From: James Thompson [REDACTED]
Sent: 25 October 2019 15:14
To: Planning <Planning@arun.gov.uk>
Cc: Adam King [REDACTED]
Subject: A/146/19/PL - Revised Planning Drawing

Further to our telephone conversation please see attached the revised planning drawing for the purposes of validating the application for Land rear of 1 The Heathers, Arundel Road, Angmering.

Proposed Bungalow
Plans and Elevations

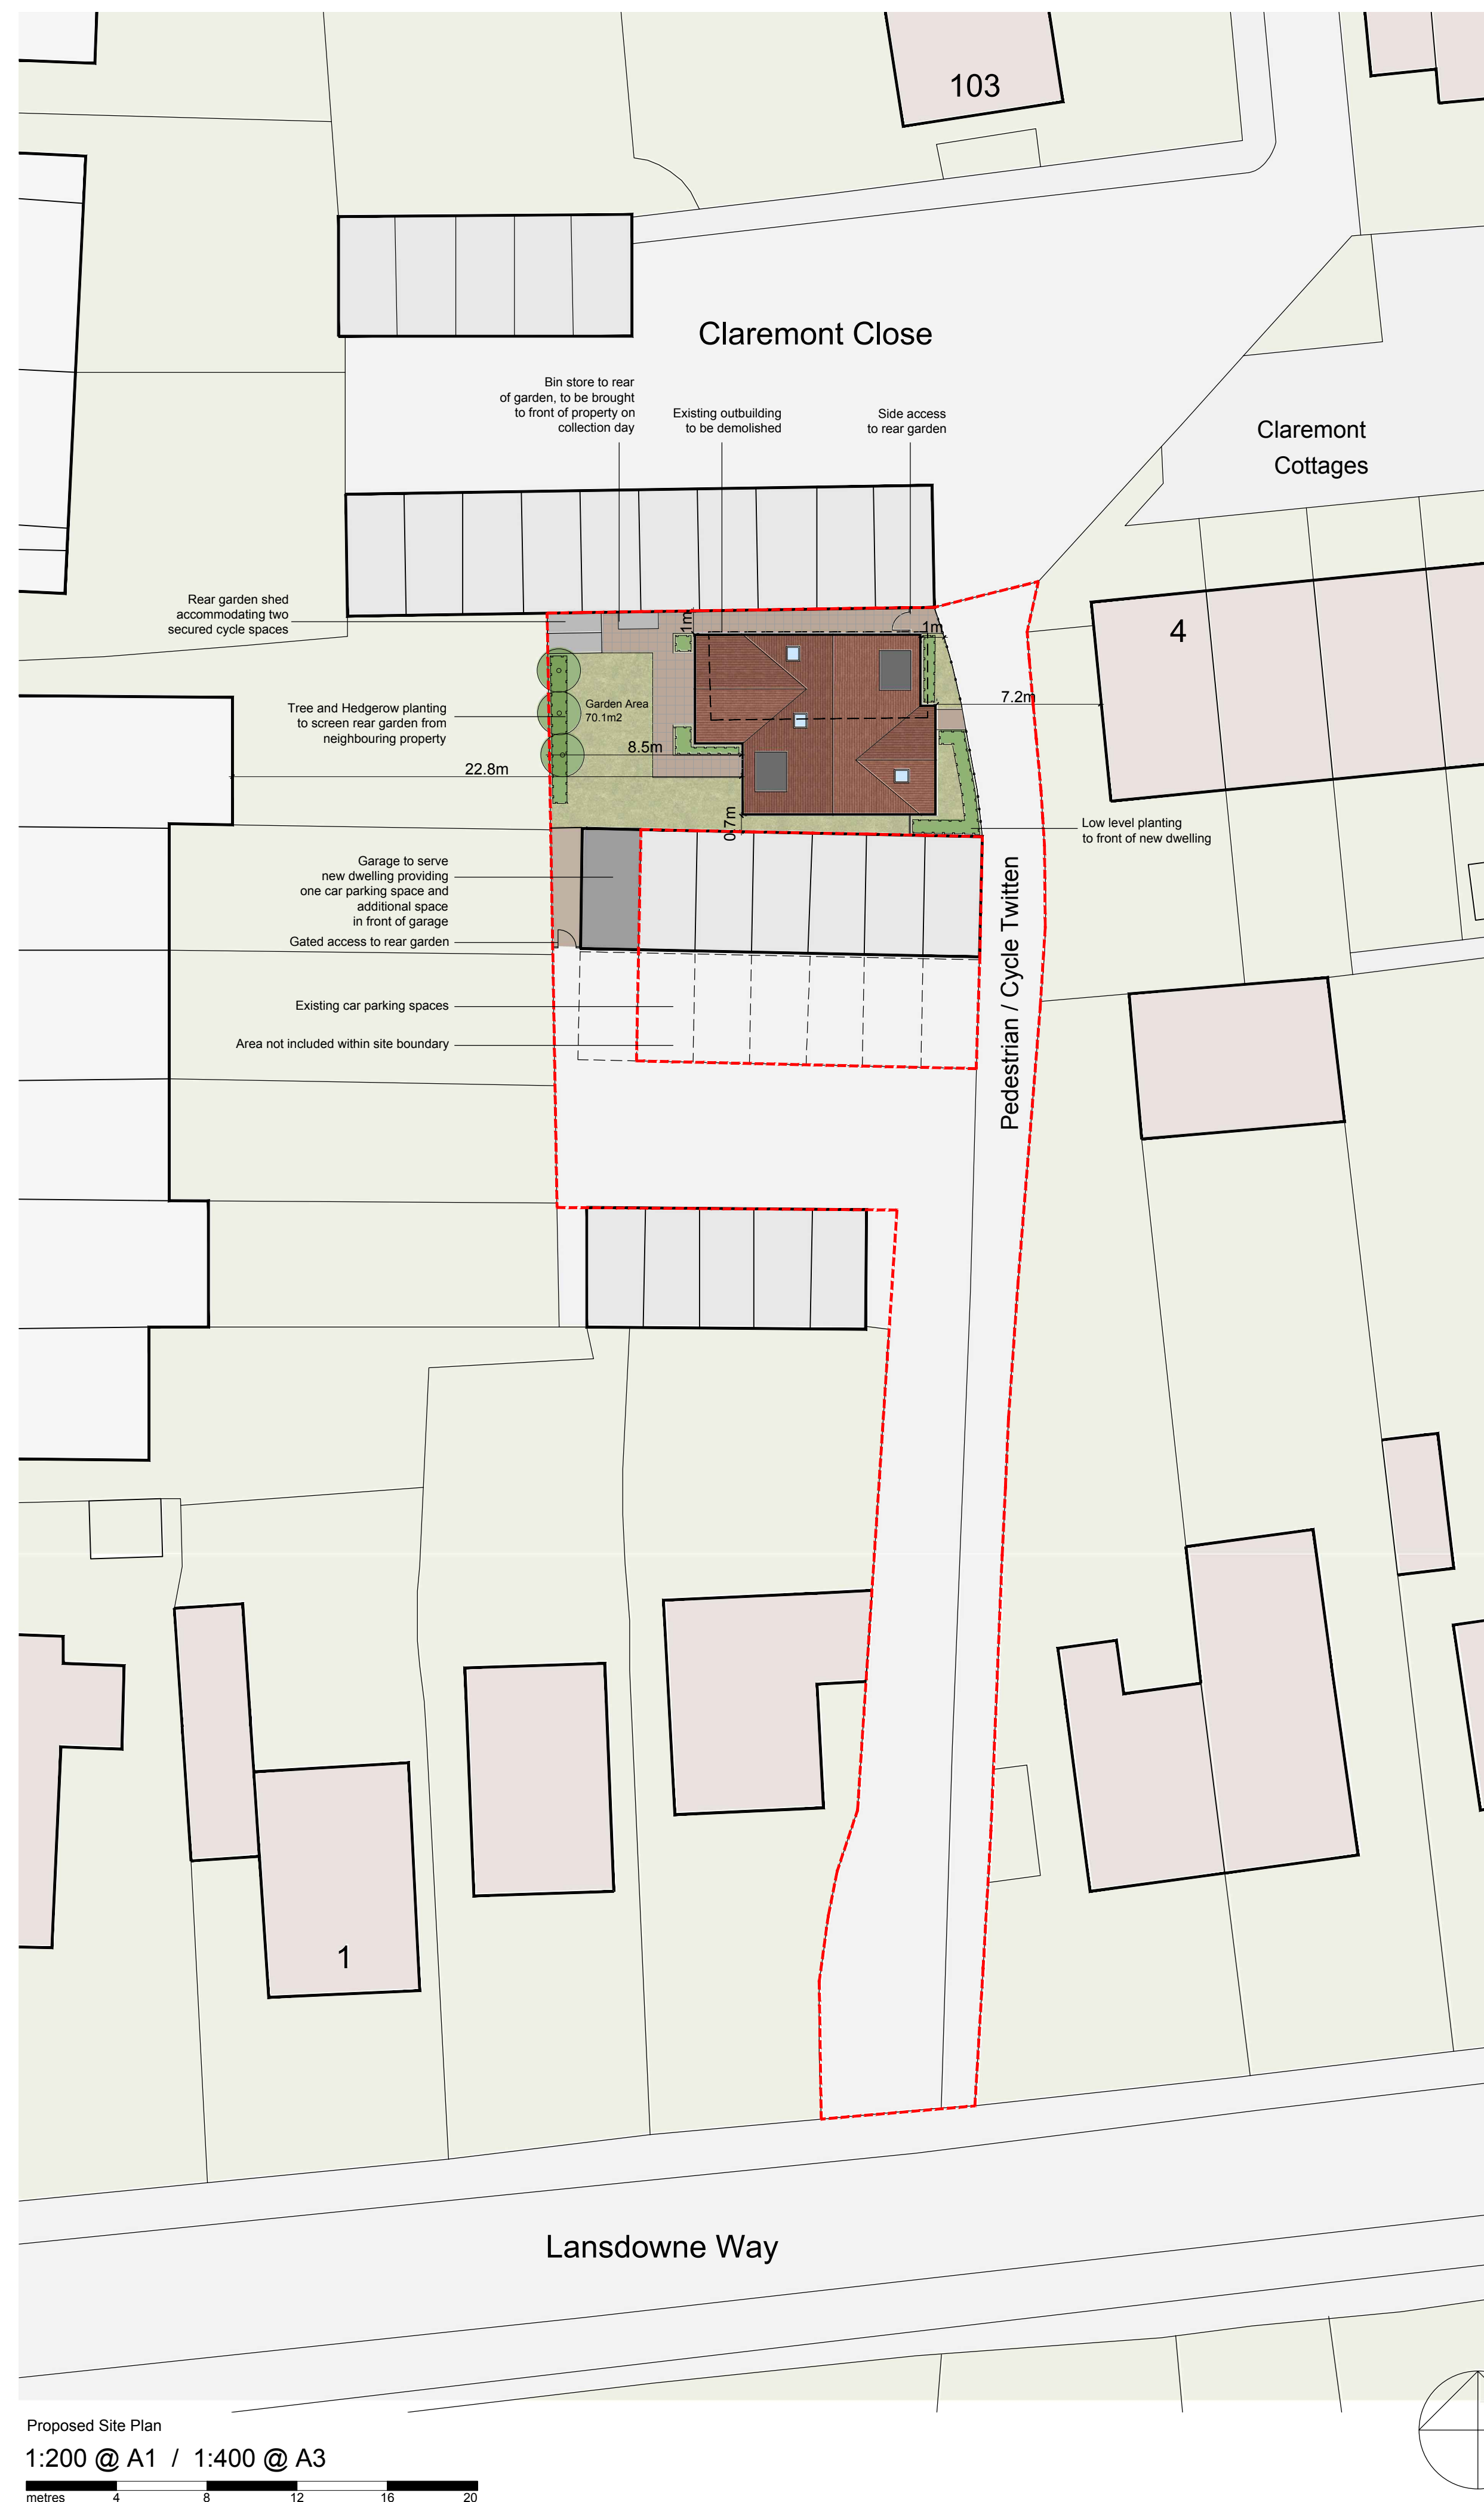
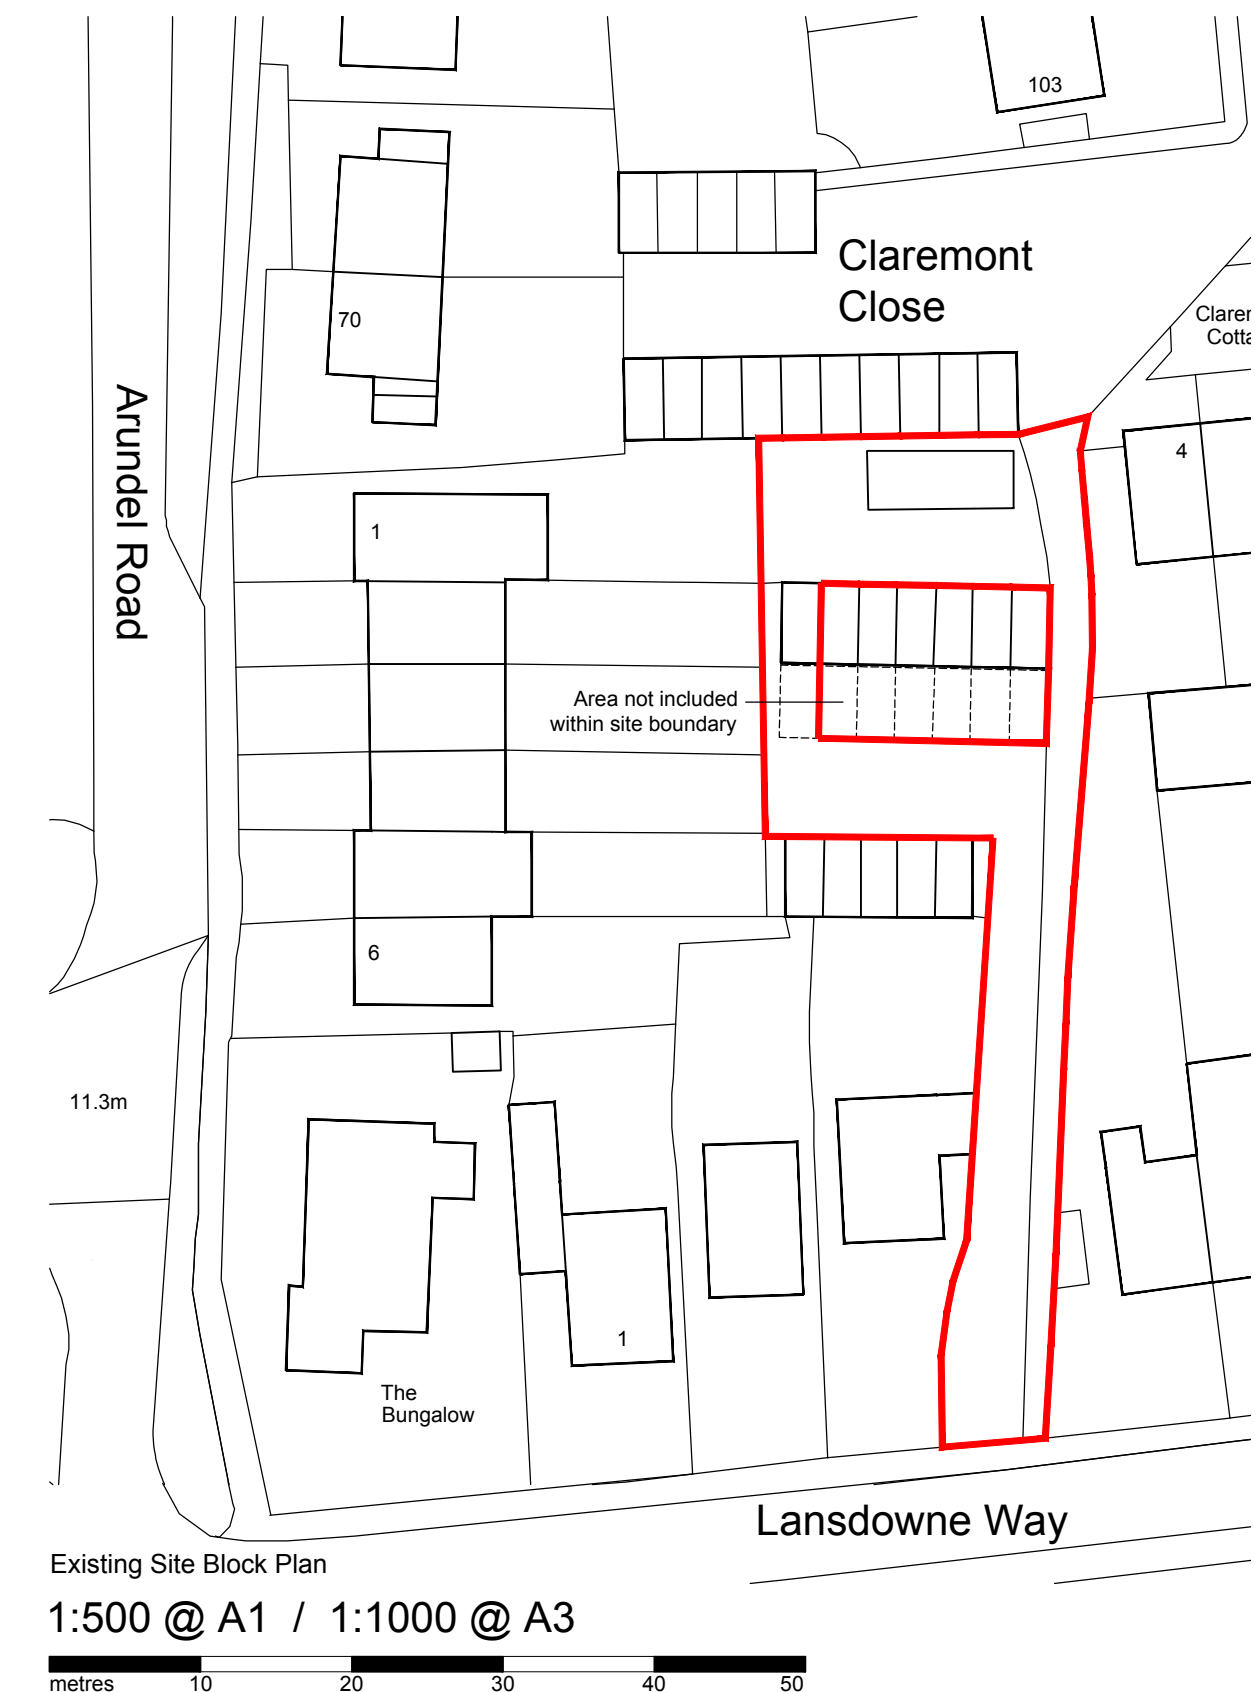
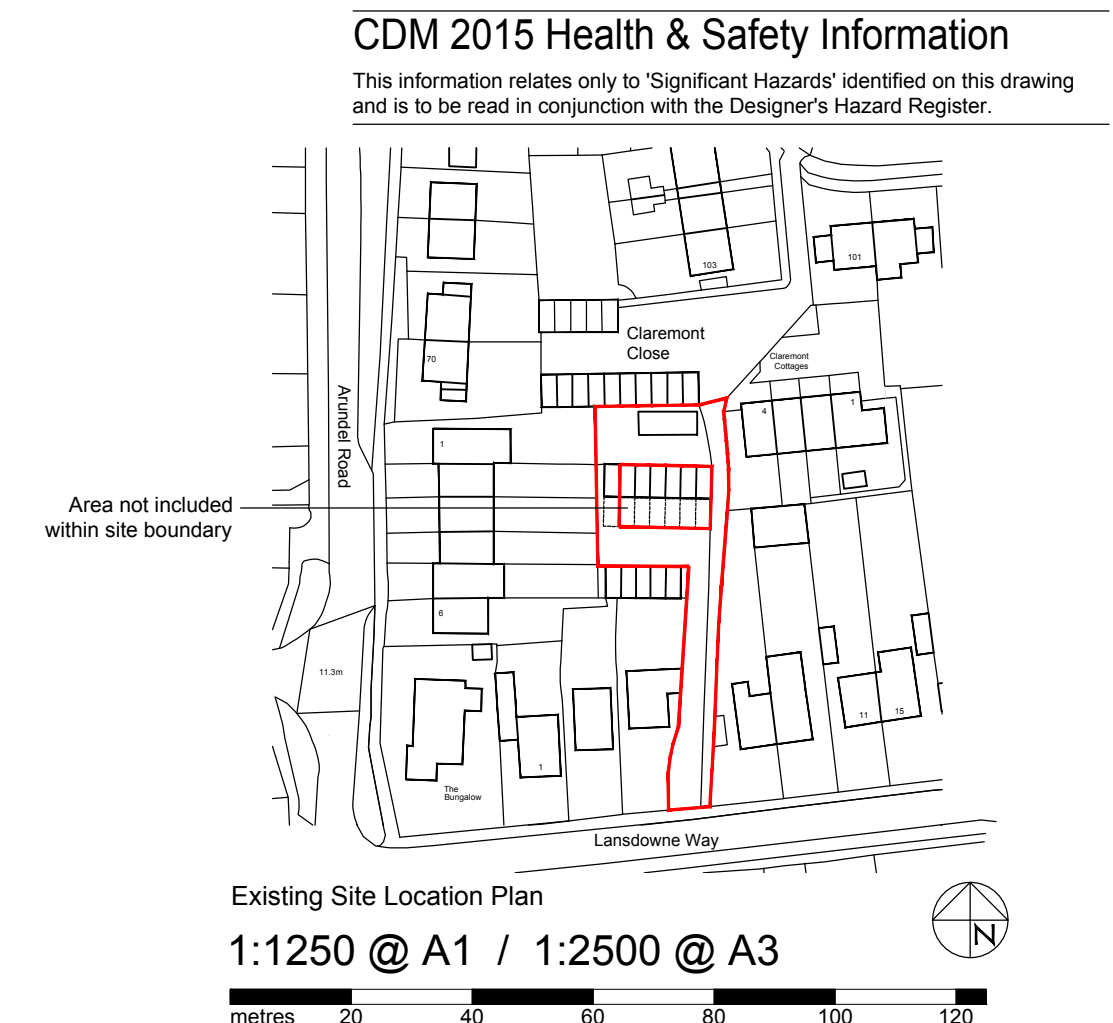
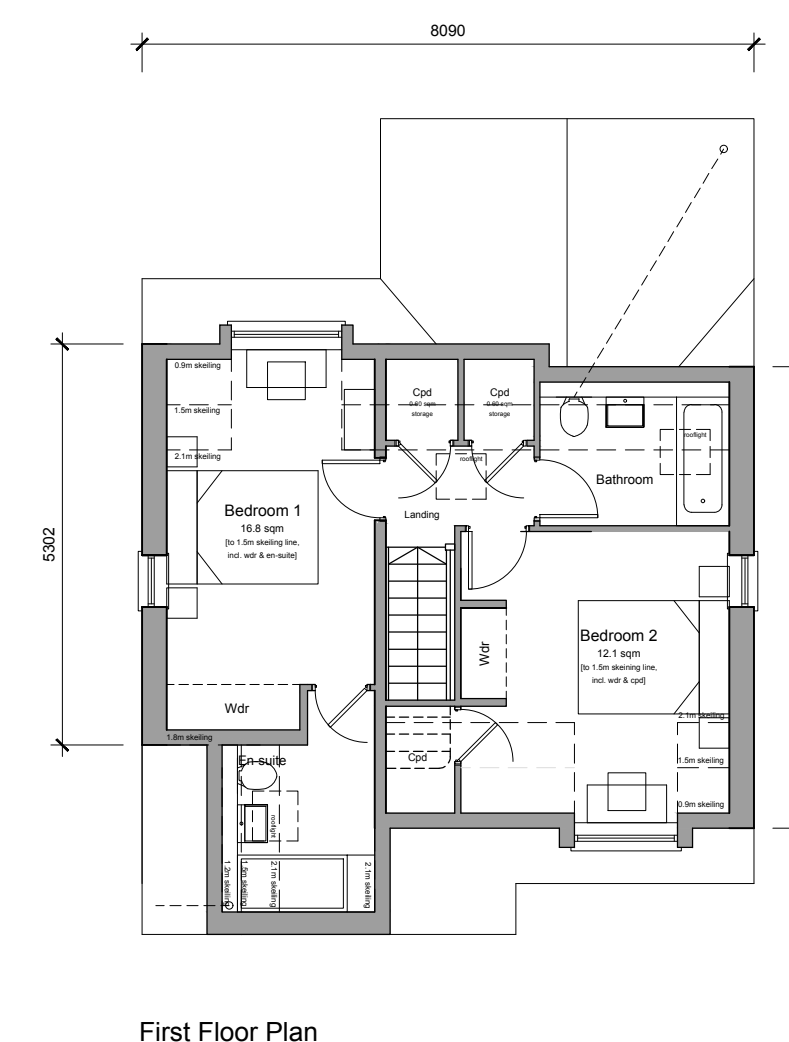
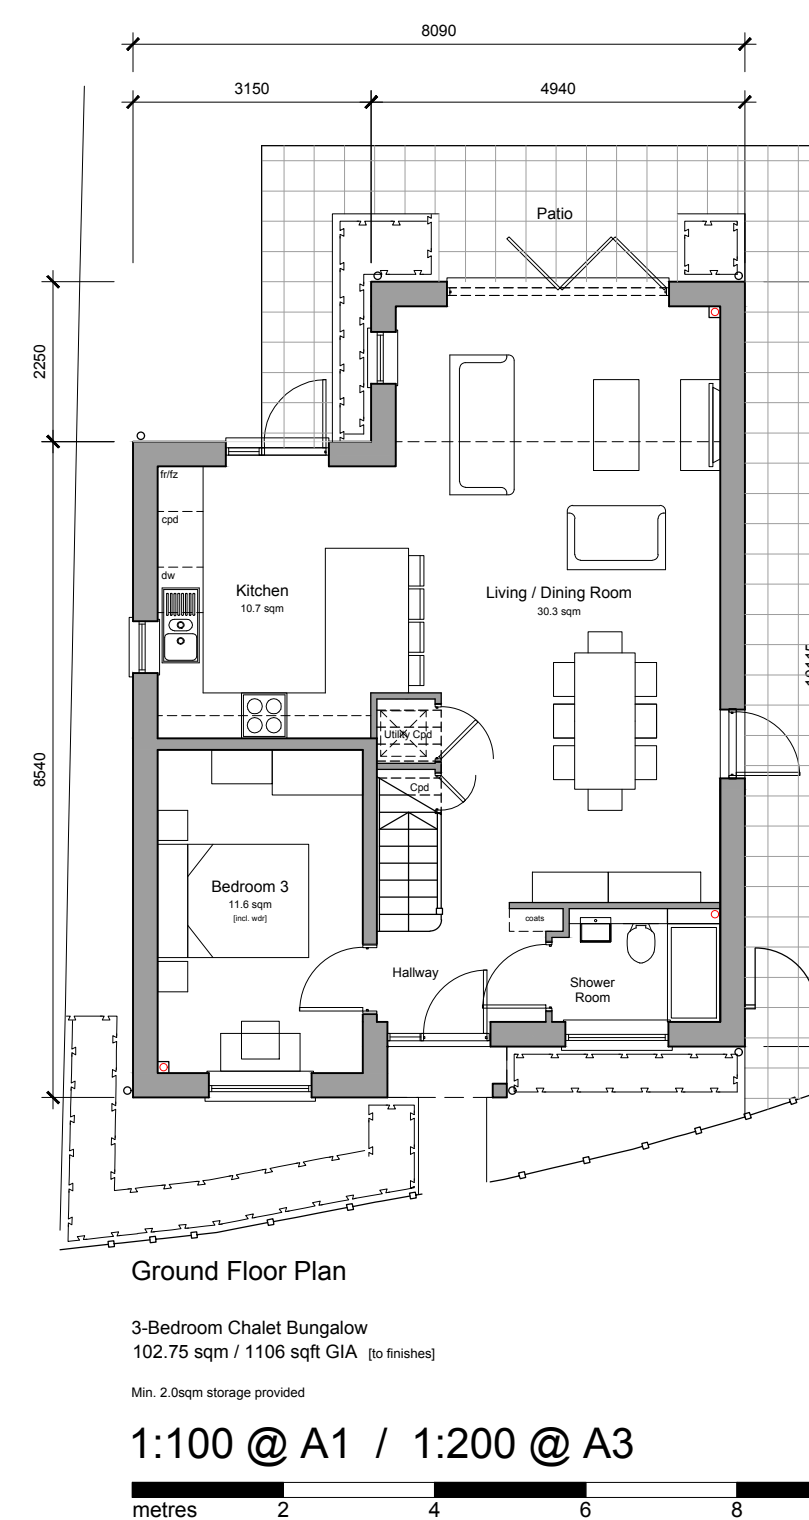
On the location plan, the named road is not correct. Please amend accordingly and provide another named road. Also, please clearly show the access to the site within the red edge. – As per our conversation, the google map and OS map ordered incorrectly stated the road as Lloyd Goring Close. As per your suggestion this has been changed to Claremont Close. Arundel Road and Lansdowne Way have now been added as additional road

On the block plan, the named road is not correct. Please amend accordingly. – Similarly, this has been amended as above.

names in the location and block plan. The access to the site from Lansdowne Way has also been included within the red line.
